R/230/21/DOC

Elm Cottage 30 The Street Rustington BN16 3NX

Approval of details reserved by condition imposed under ref R/305/18/L relating to Condition No 3 - materials, finishes and joinery.

First Floor Front W1

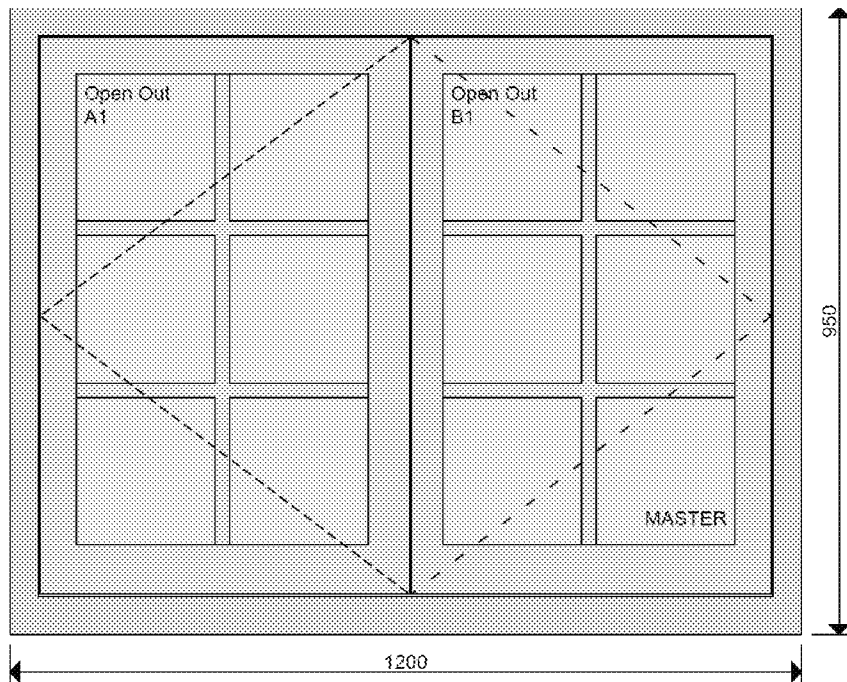
In my previous consultation comments on applications R/304/18/HH & R/305/18/L I stated that Windows are an important feature within a listed building, and their replacement should be carefully considered. However, it was not clear if the double-glazed units were to be of a 'standard design or dimensions' (such as 24-18mm), or the slimmer design (such as 12-14mm) which is sometimes considered acceptable in listed buildings. I stated that if the units are of the 'standard design', and measurements, then their use will not be supported. A review of the proposed glazing is that it is to be the 'standard design and dimensions. As a result, I cannot support the application. Further, it is not clear if the glazing bars are applied to a larger sheet of glass or are integral to the frame.
